PROJECT NAME: PARKWEST PARK IMPROVEMENTS
LOCATION: PARKWAY DR., N. OF LADDER CHANNEL

**RE: GRADING & DRAINAGE PLAN FOR PARKWEST PARK (H-9/D1A4)
RECEIVED MAR 22, 1999 FOR DRC WORK ORDER
ENGINEER'S STAMP DATED ?-?-99**

Based on the information included in the submittal referenced above, City Hydrology has the following comments:

TITLE: **PARKWEST PARK IMPROVEMENTS
DRAINAGE & GRADING PLAN & BASIN DEFINITION**

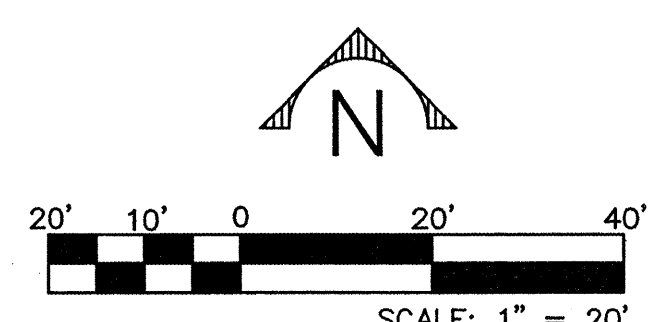
Please date your stamp. This is how we identify different submittals. The proposed contours on Sheet 4 are mess. Clean the ^wup so that they match the proposed contours on Sheet 6.

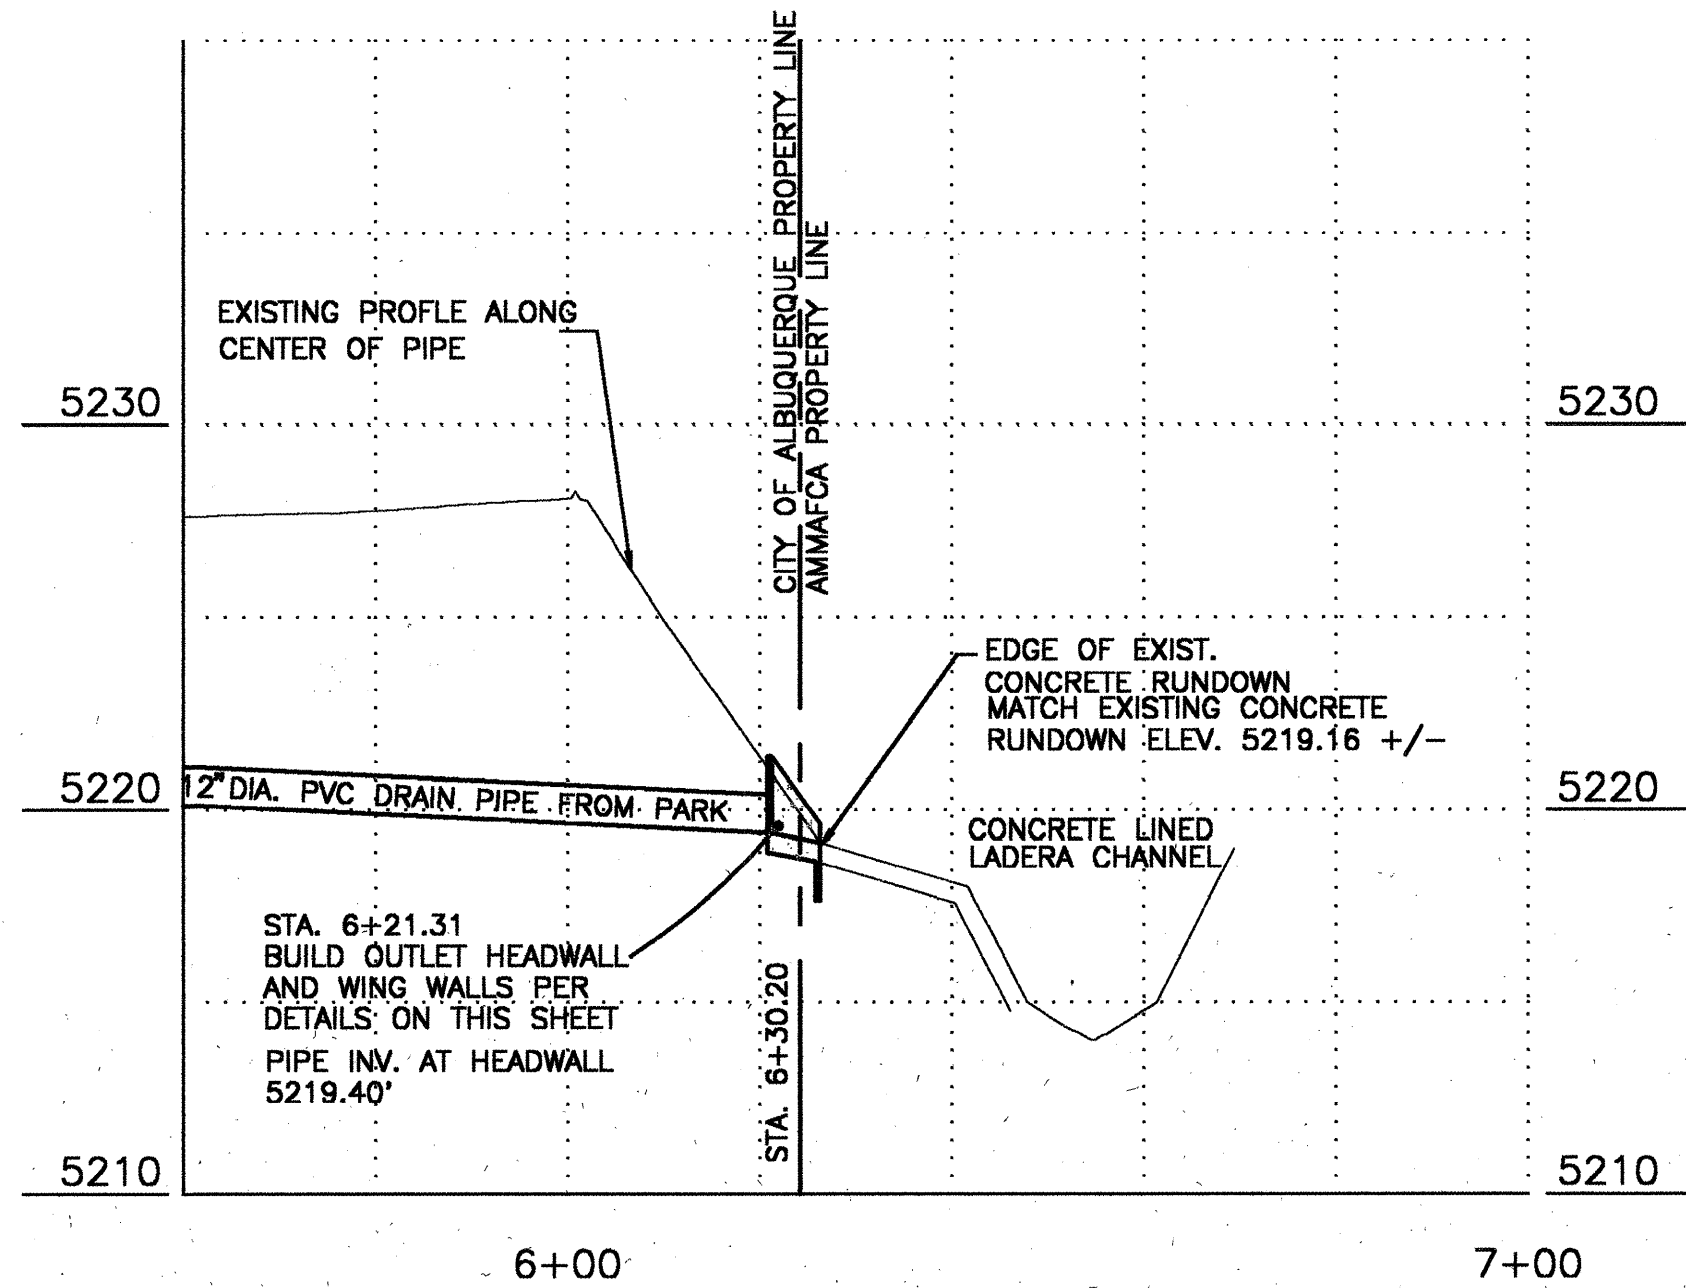
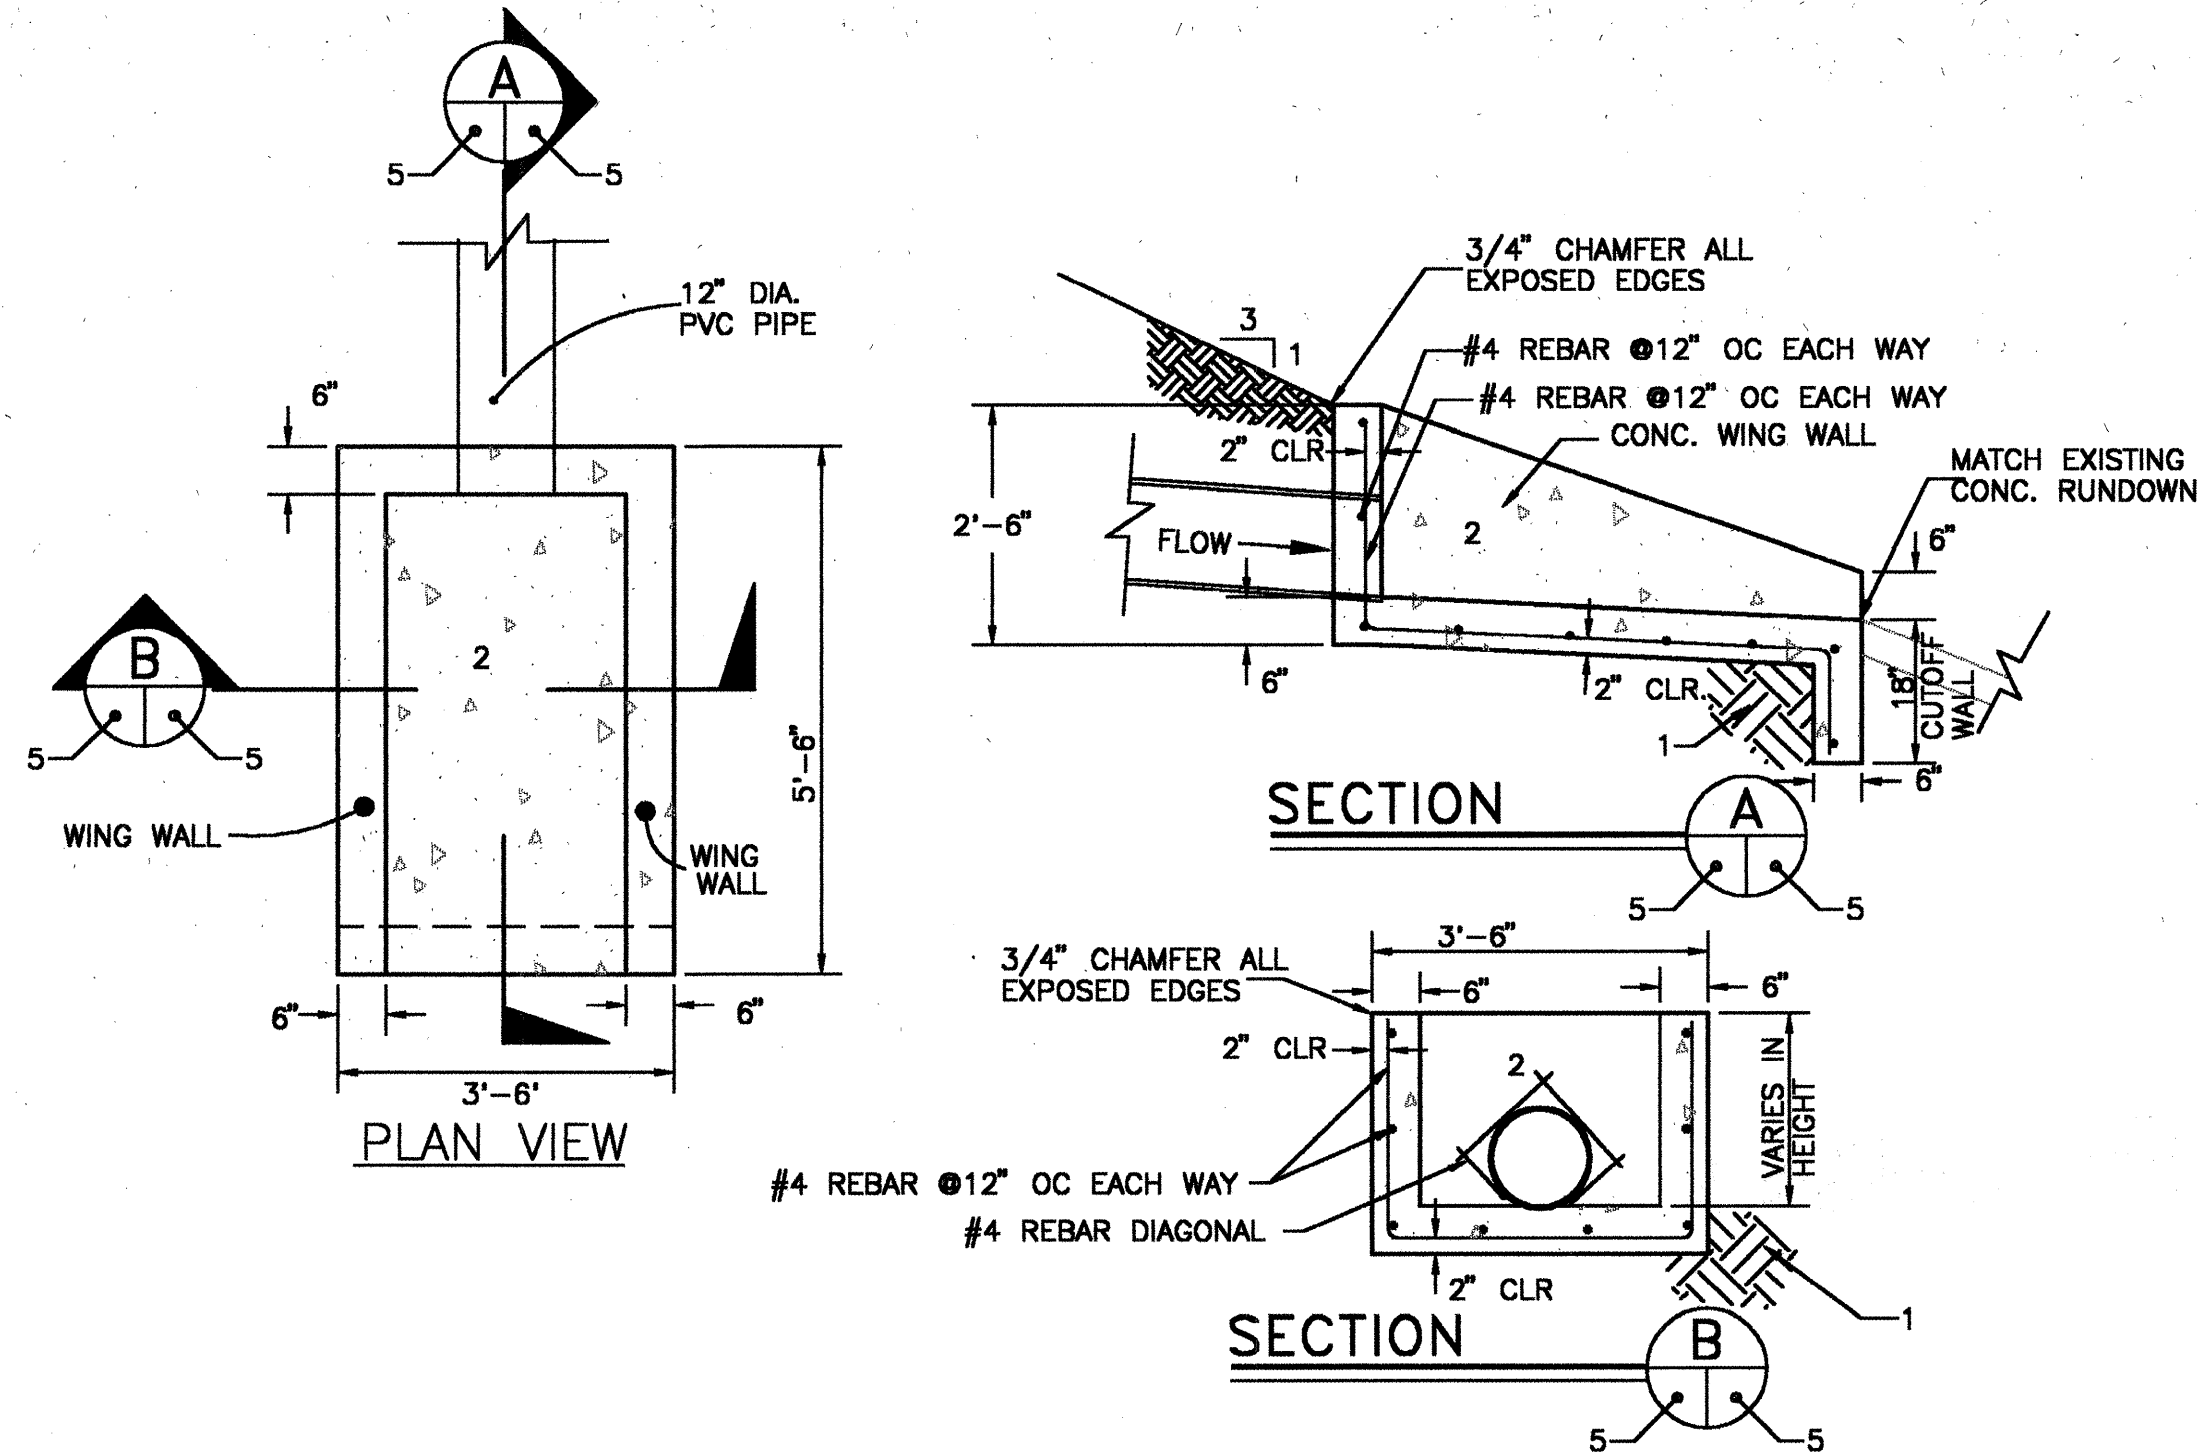
There are several typos on Sheet 5. I believe that access is from Parkwest Drive instead of Park side. Existing 100 yr flow is 3.4 instead of 5.8. Basins A & C are Land Treatment A instead of B. Basin C drains to Parkwest Drive instead of B. Basin A also drains to the Channel. The area for the 10 yr volume should be 2.5203 instead of 2.5183.
